DOC17/599447-01
SSD 8647

SSD 8647 – HORNSBY HOSPITAL RE-DEVELOPMENT – ENVIRONMENTAL IMPACT STATEMENT (EIS)

HORNSBY HOSPITAL RE-DEVELOPMENT STAGE 2 EIS

APPENDIX 2 – NOISE MONITORING ALONG DERBY STREET

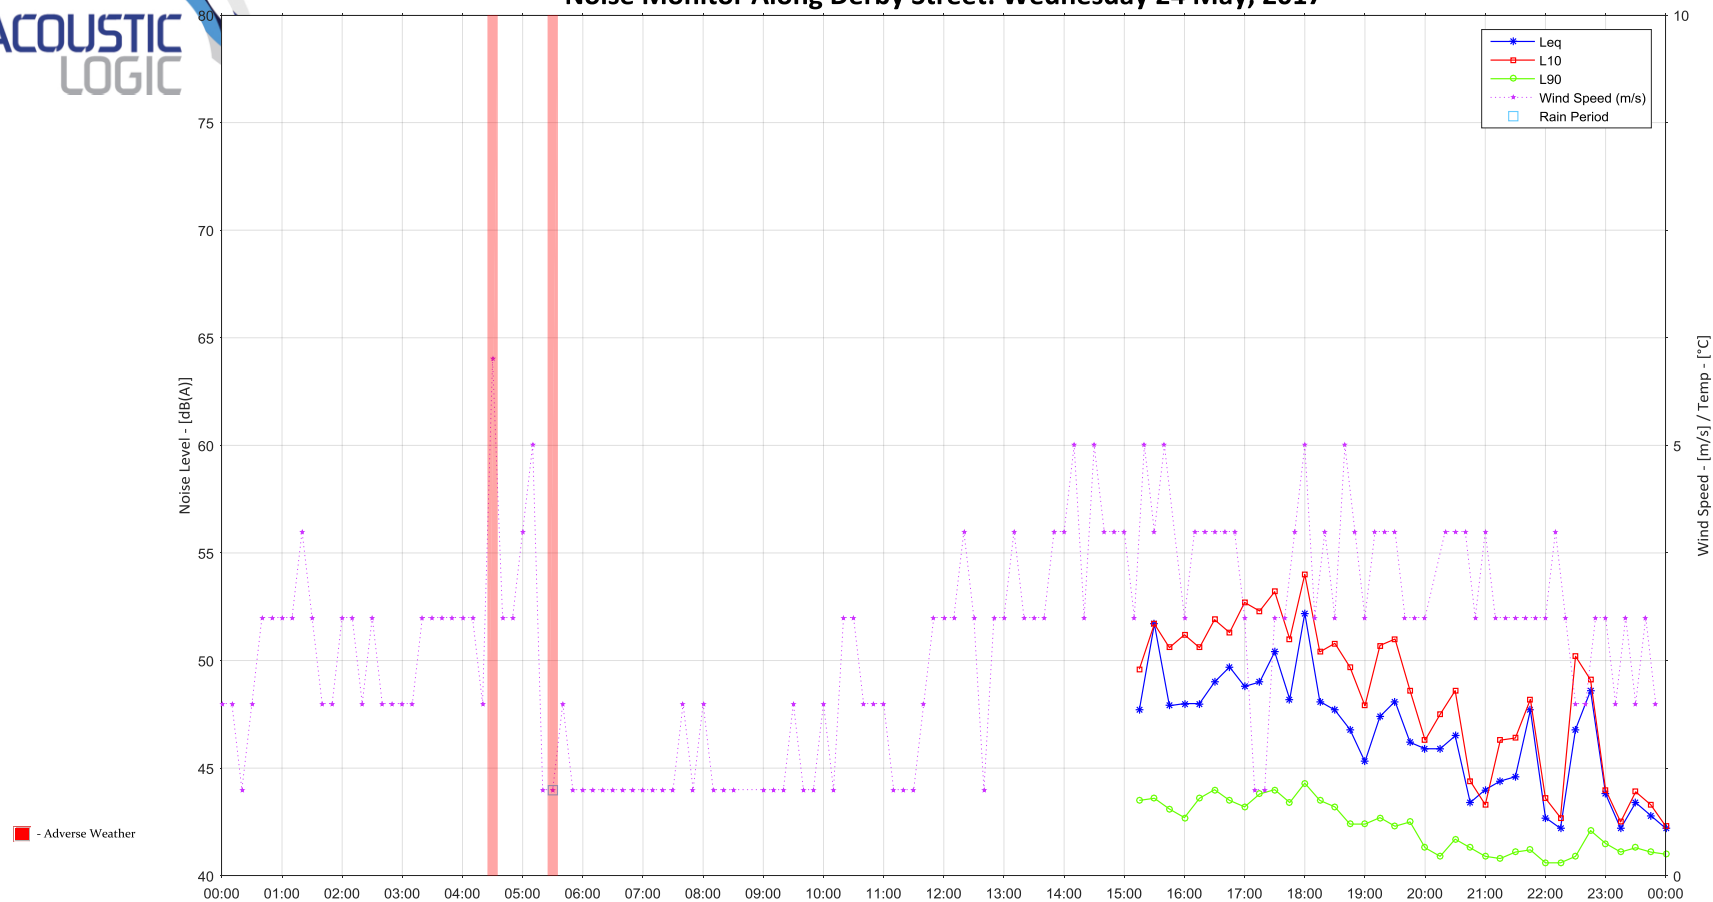
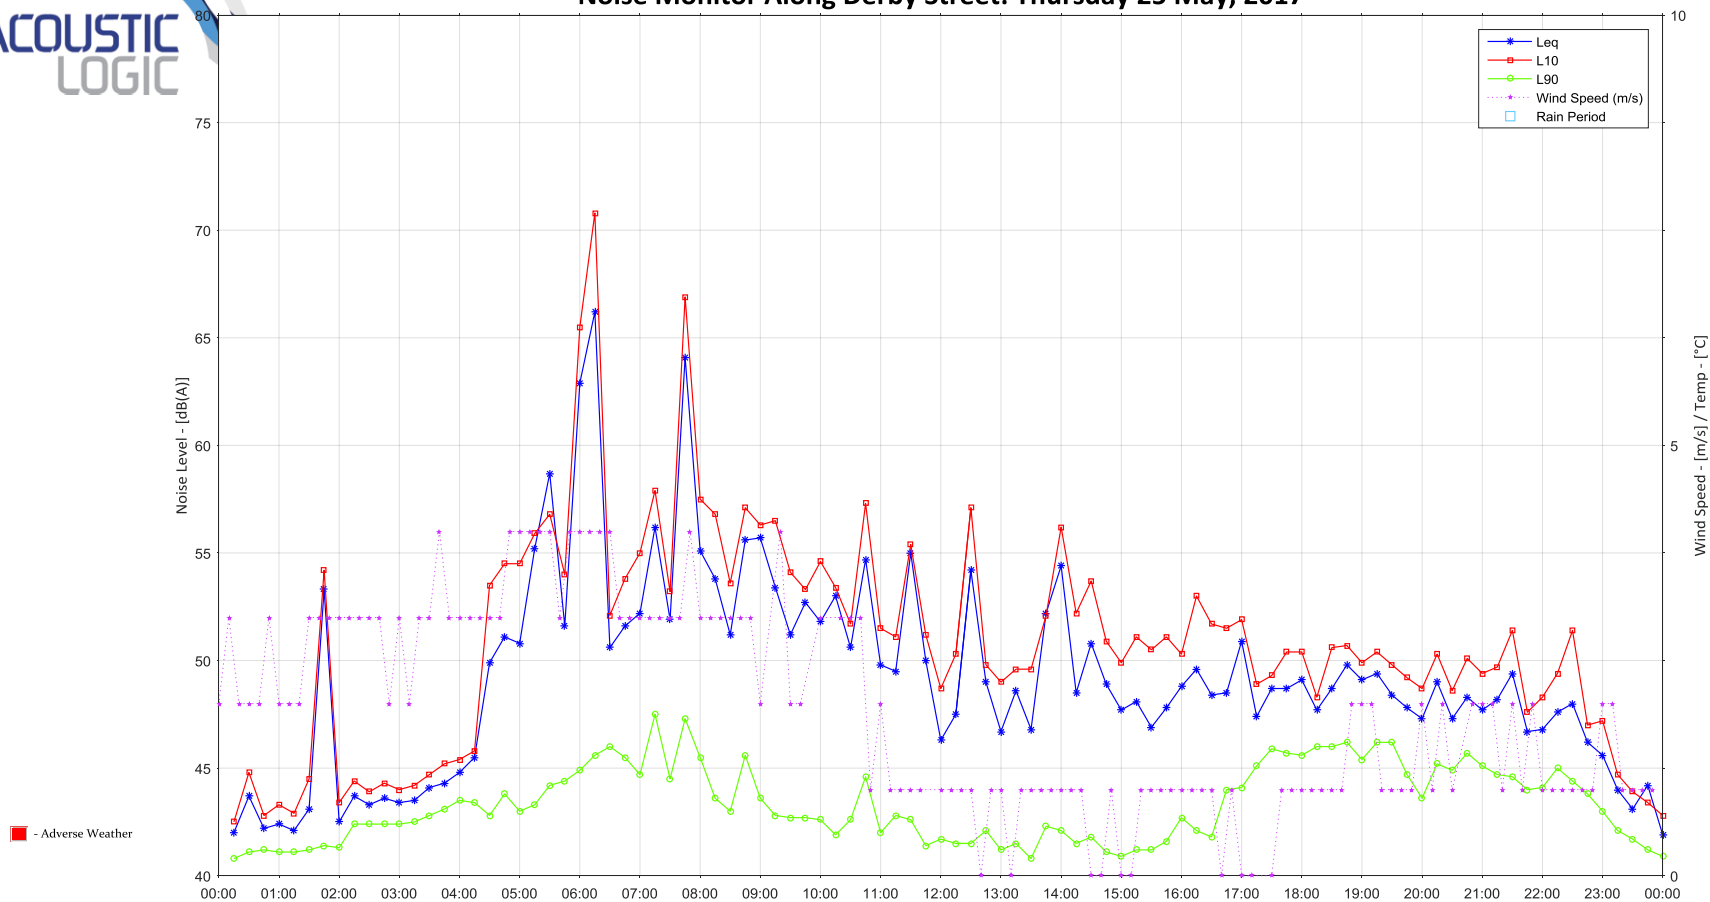
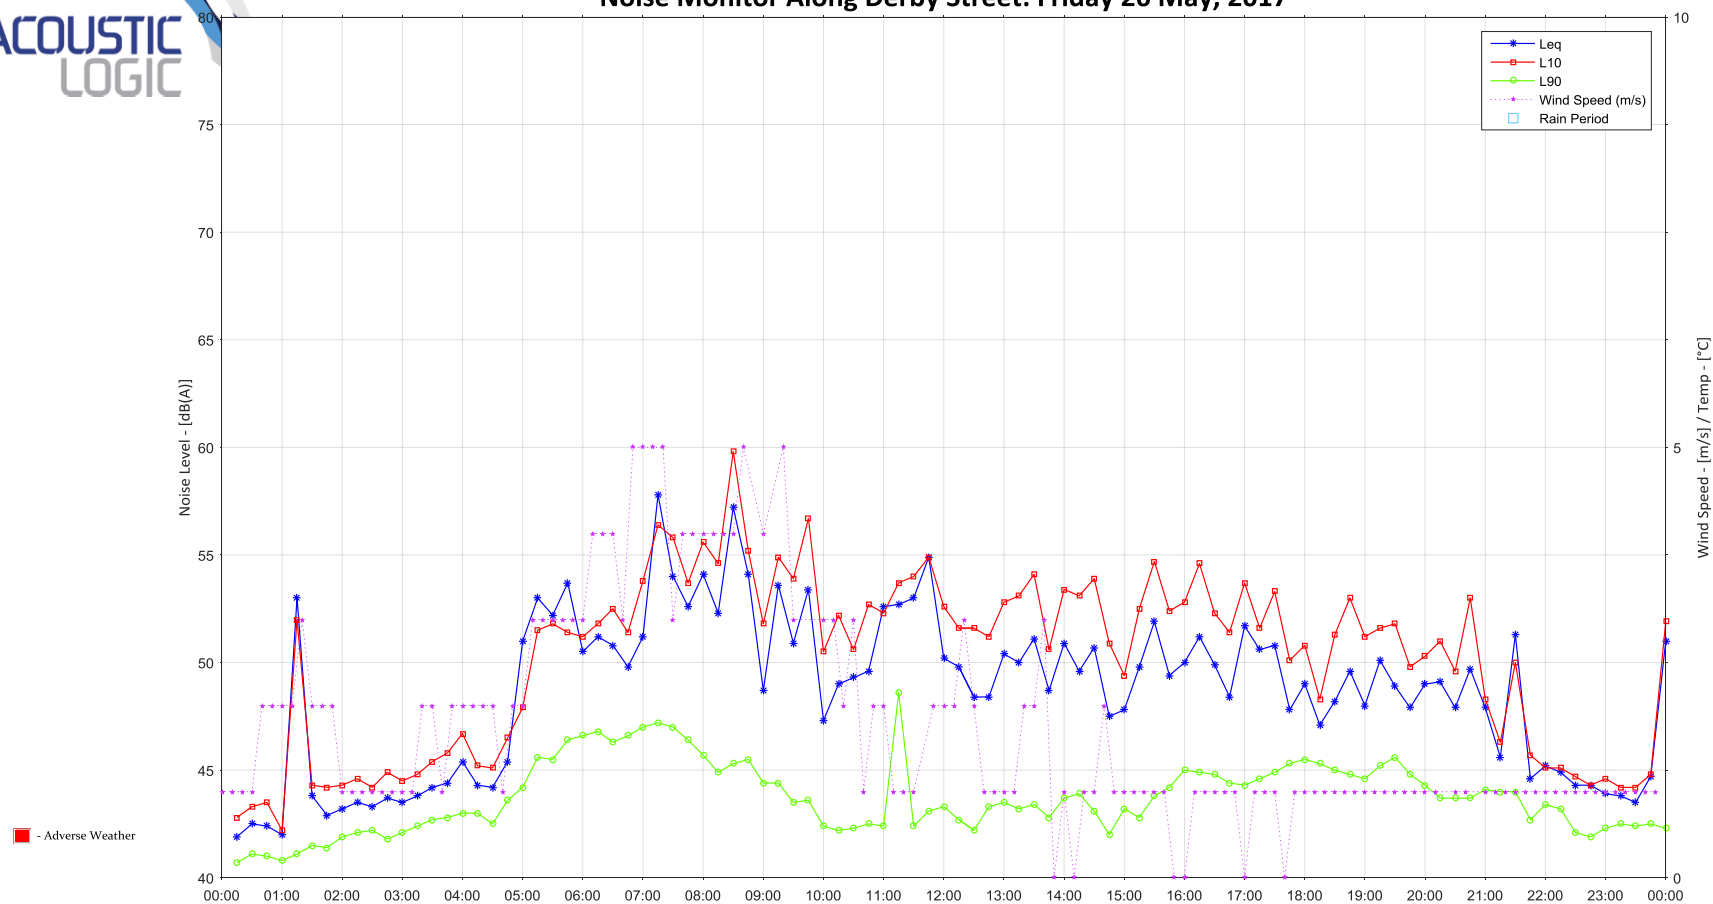
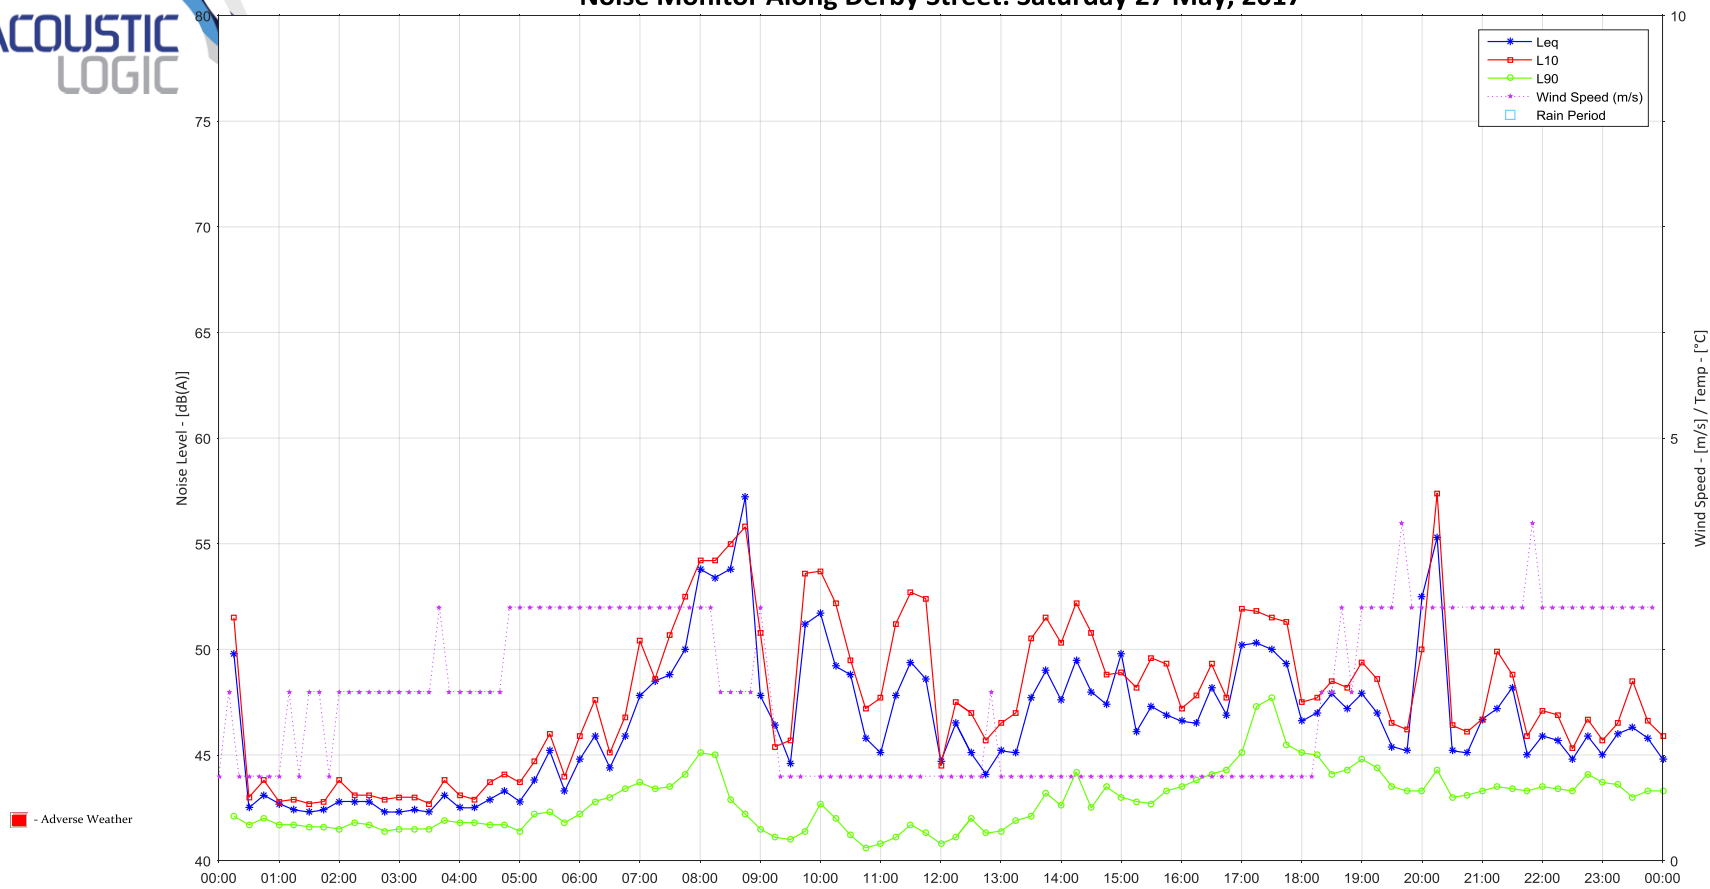
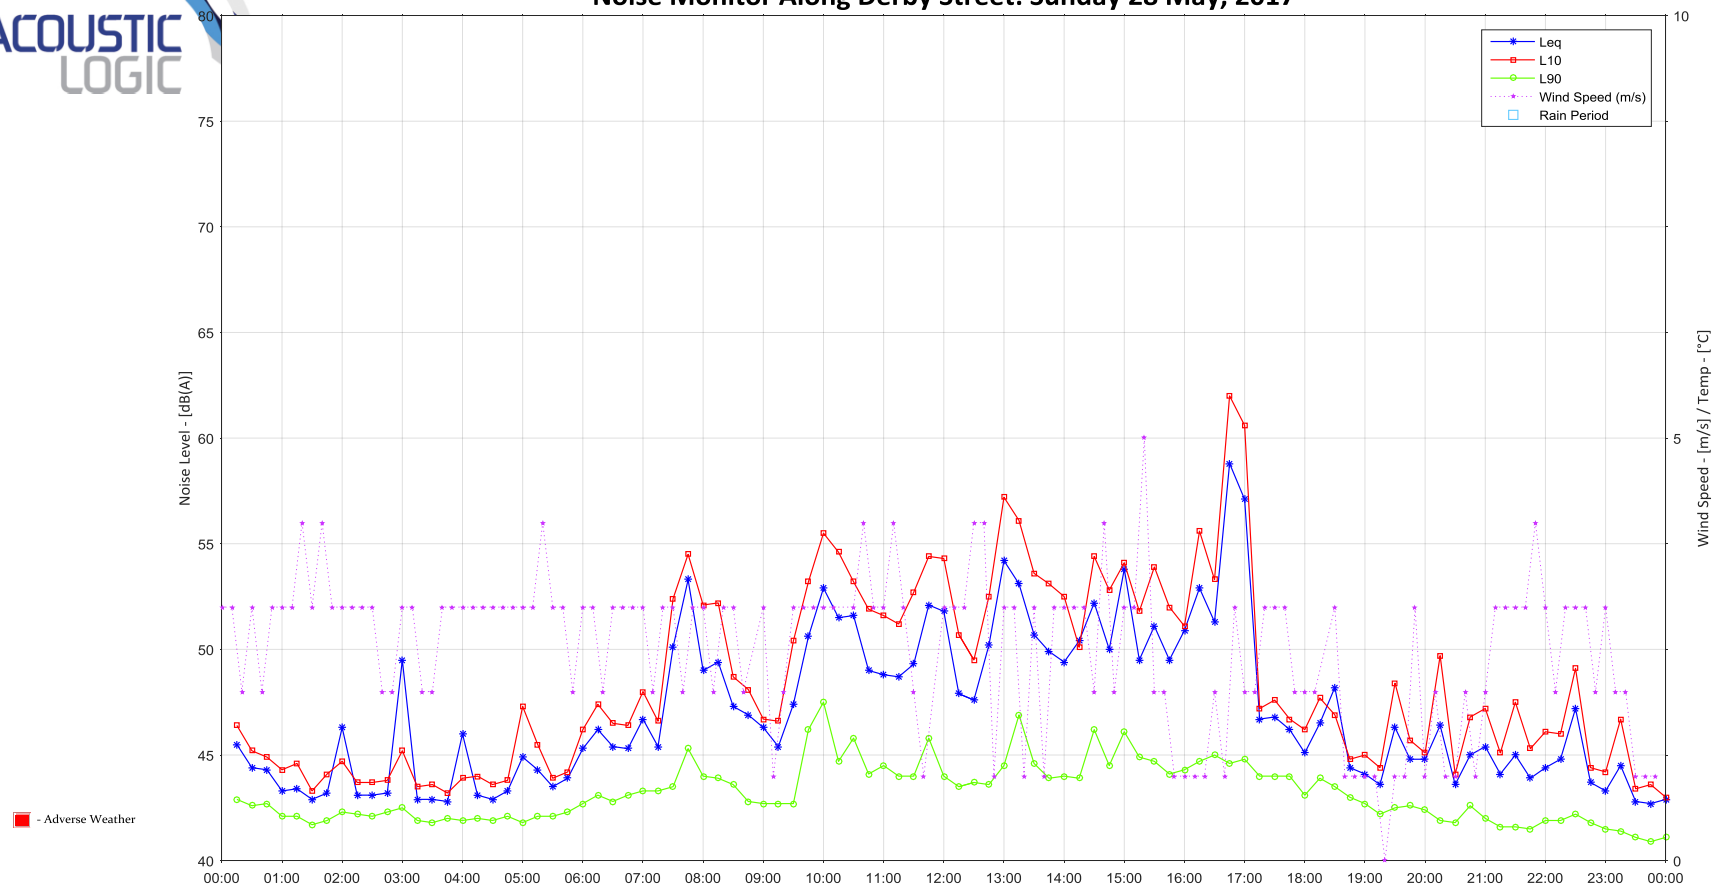
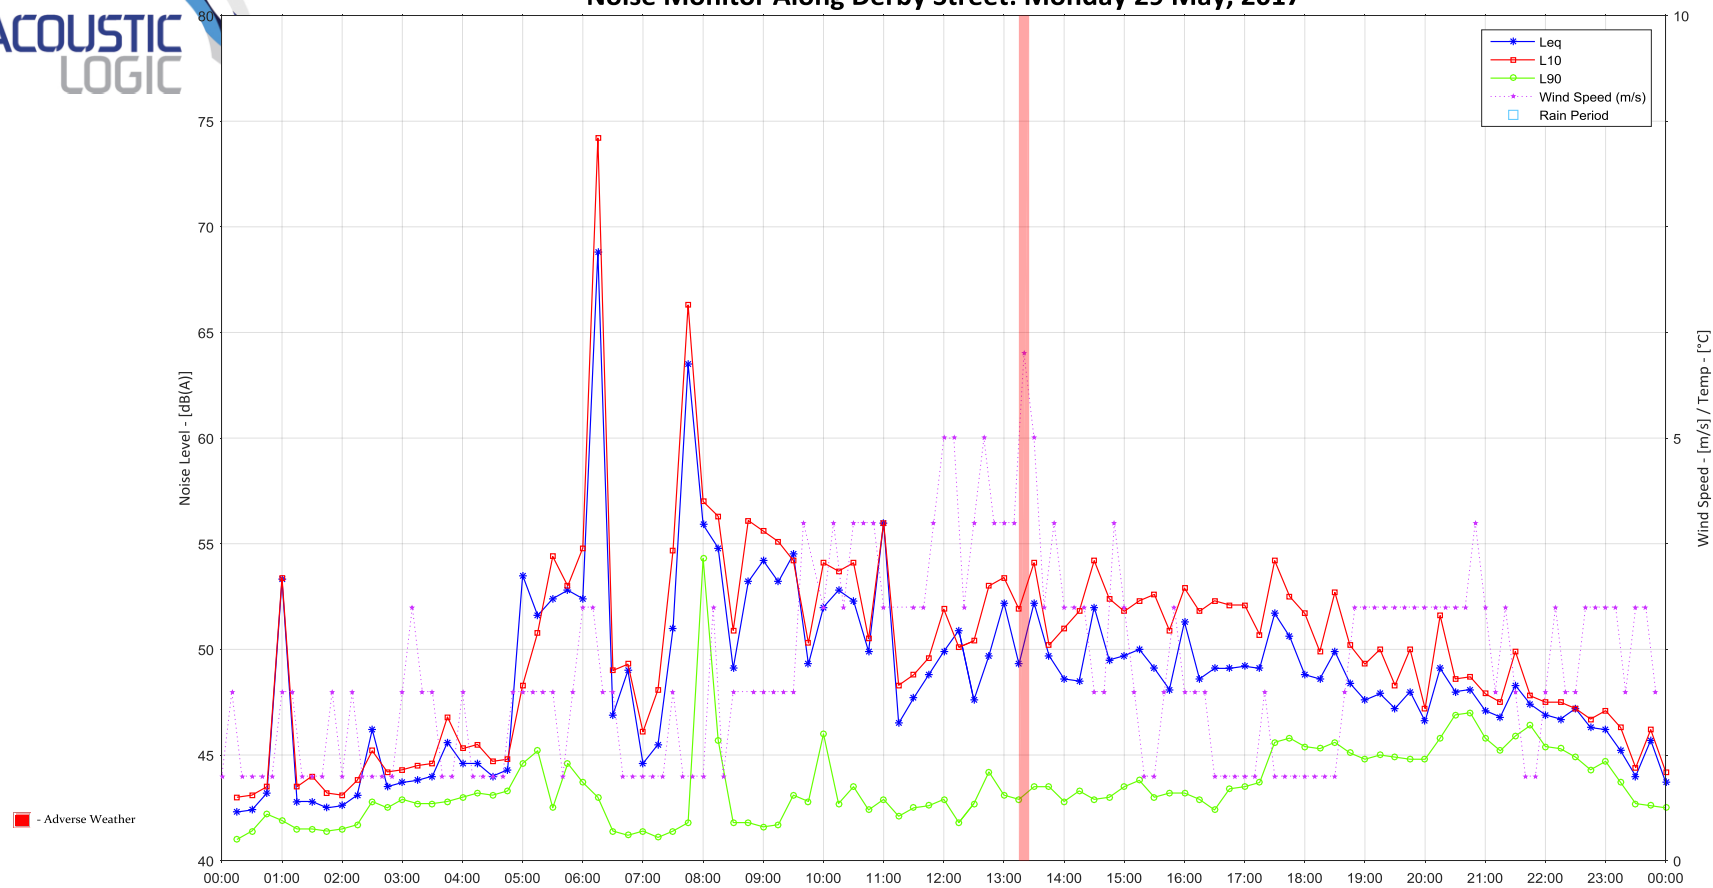
The EPA is concerned that the noise monitoring graphs presented in 'Appendix 2 - Noise Monitoring Along **Derby Street**' to EIS Appendix Q appear instead to be a duplicate of graphs for Burnett Street and thus that the data for Derby Street appears to have been omitted from the EIS.

- (a) the equivalent of a week's worth of valid data, measured at the potentially most affected noise sensitive receiver locations in Burdett Street, Derby Street and Palmertson Road; and
- (b) the results of attended monitoring, graphical results of unattended monitoring with a complete and accurate legend together with a table of assessment background and daily ambient levels.
